STATE OF WASHINGTON
DEPARTMENT OF ECOLOGY

RE: Kittitas County Permit SV-14-00001
Richard Landen - Applicant
Incomplete Shoreline Variance Permit Ecology #VAR-282

SP-1

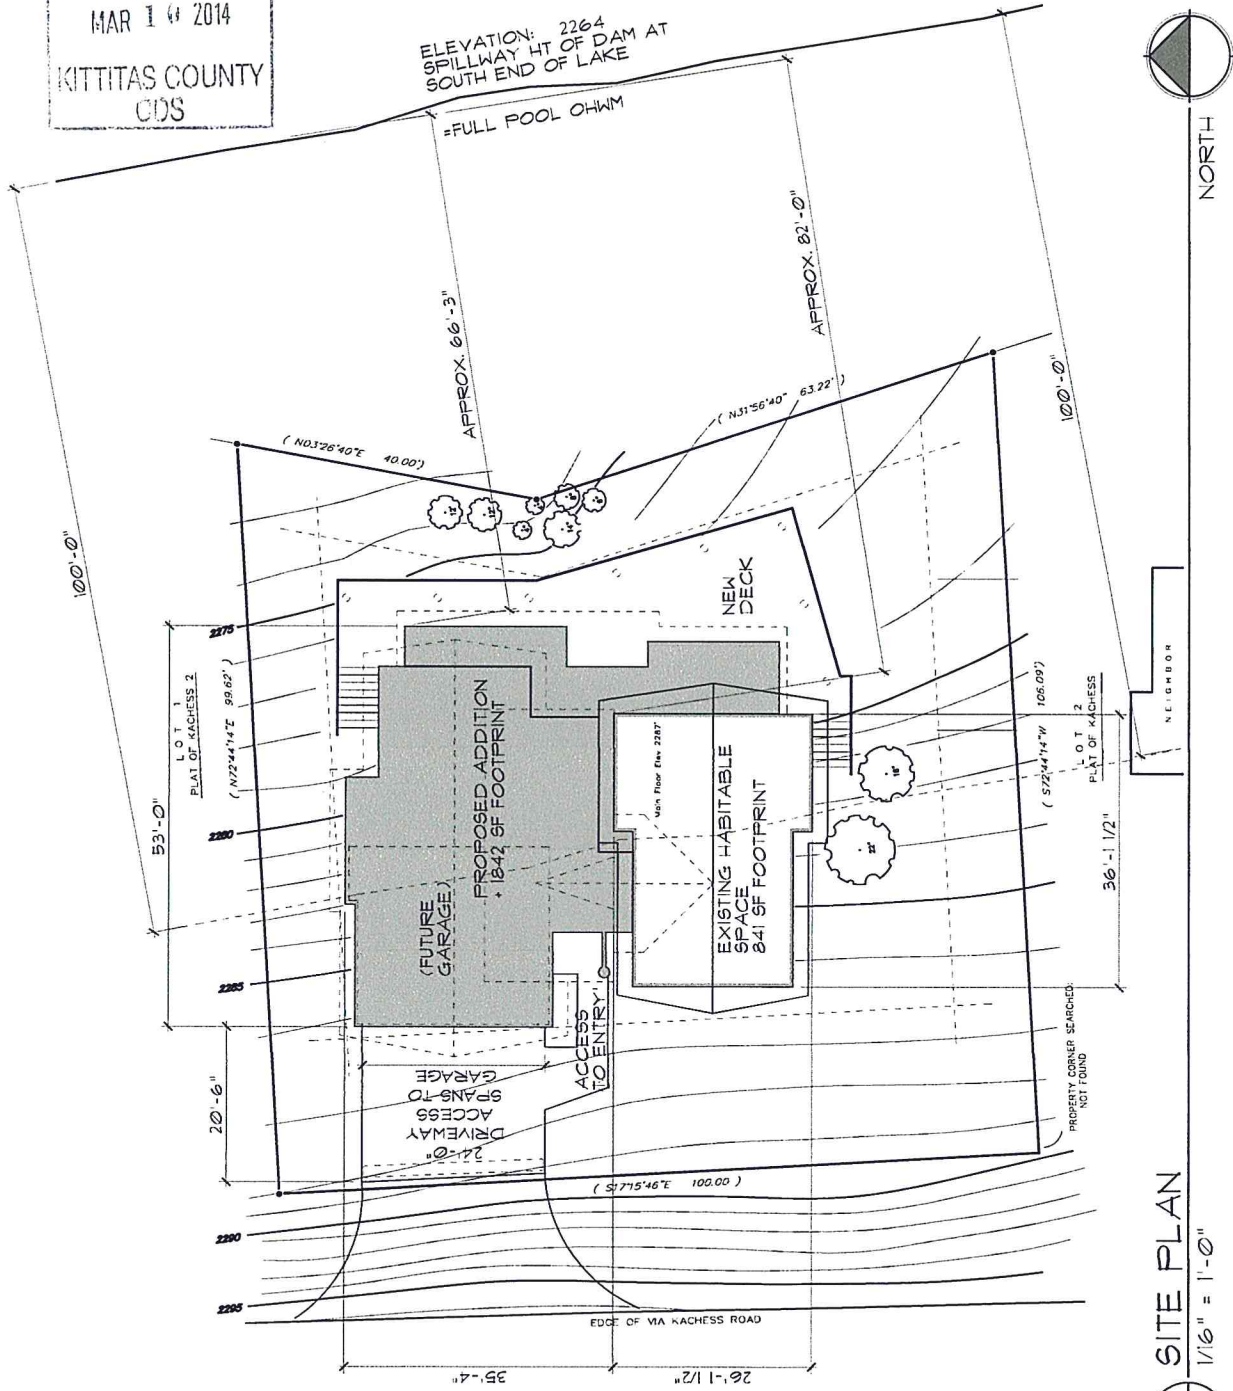
- A clear drawing of the additional deck area. The drawing should include dimensions of the deck expansion.

- A narrative which discusses the proposed deck expansion dimensions, and how those dimensions are the minimum necessary to afford relief for handicapped access. (The Shoreline Management Act (SMA) provides clear language that variances or intrusions into setback areas are granted for only that amount that is absolutely necessary to make the project (deck) functional. The turning radius of the wheelchair and any ADA standards for width would be important information to evaluate the need. If the deck can be designed to be smaller in width and still meet the needs of the applicant, then a new drawing of the deck footprint should be submitted in response to this letter.
